From: [REDACTED]  
To: [REDACTED]  
Subject: DCO  
Date: 14 June 2019 19:15:57  
Attachments: [RSP 18.pdf](#)

# Noise contours commissioned from the Civil Aviation Authority by No Night Flights

## NNF18

Figure 12.9
Aircraft noise - night-time L_{ASmax}
contours - year of forecast maximum
capacity

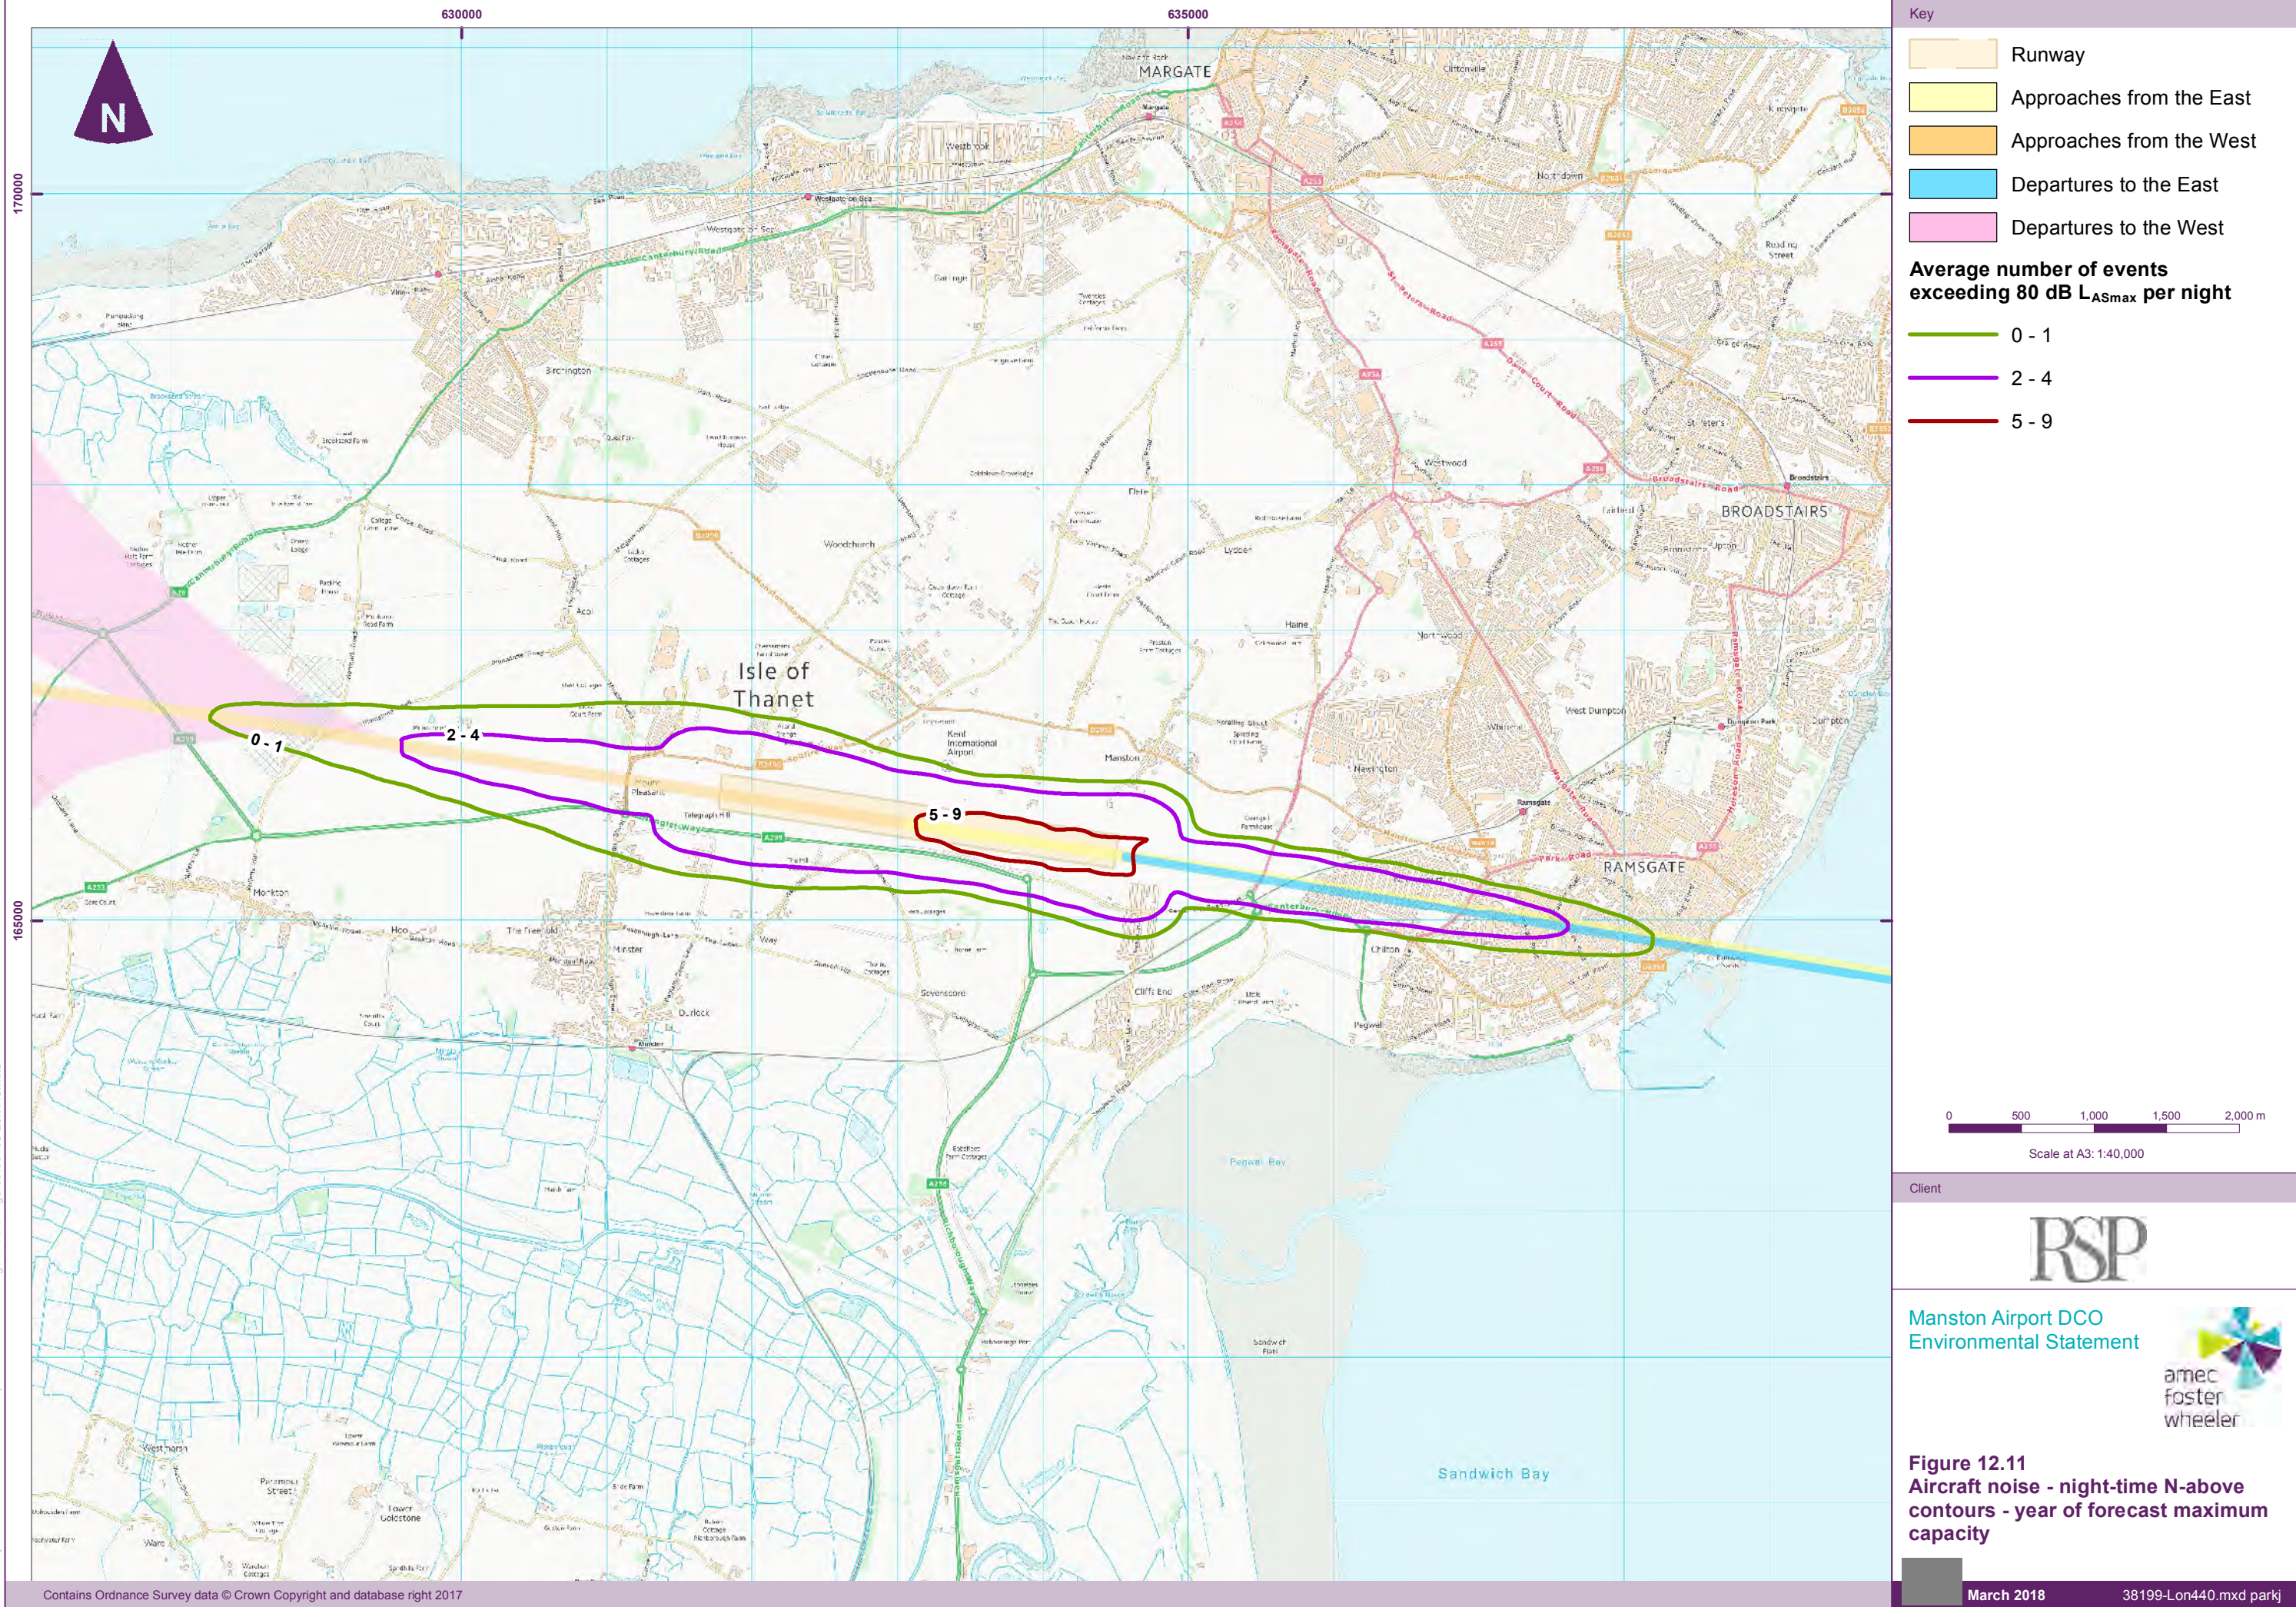
55. It is hard to compare the CAA's noise contours with those provided by RSP. As far as we can tell (it is needlessly difficult to navigate RSP's thousands of pages of unhelpfully referenced submissions, so we may have missed something), RSP has failed to model the noise impact generated by a single 747-400 flight on each of the five available routes. The nearest comparators that we can find are RSP's LASmax night contours for Year 20.<sup>10</sup>

56. A comparison of RSP's Figure 12.9 (page 63) with NNF's Maps 1 and 2 reveals a significant noise impact that RSP has simply not shown. The 70dB contours extend over the entire town of Herne Bay in the NNF contours. RSP has only modelled 80dB LASmax and so Herne Bay does not even appear on its maps. This suggests that Herne Bay will be entirely unaffected by aircraft noise – an assertion often made by the RSP team at various consultation events. However, Herne Bay residents know from experience that a single 747-400 creates a significant noise footprint. A 747-400 overflying Herne Bay in the daytime is loud enough to make people look up as it goes over. At night, the impact is greater. The real impact on Herne Bay residents is entirely missing from RSP's assessment of noise impact.
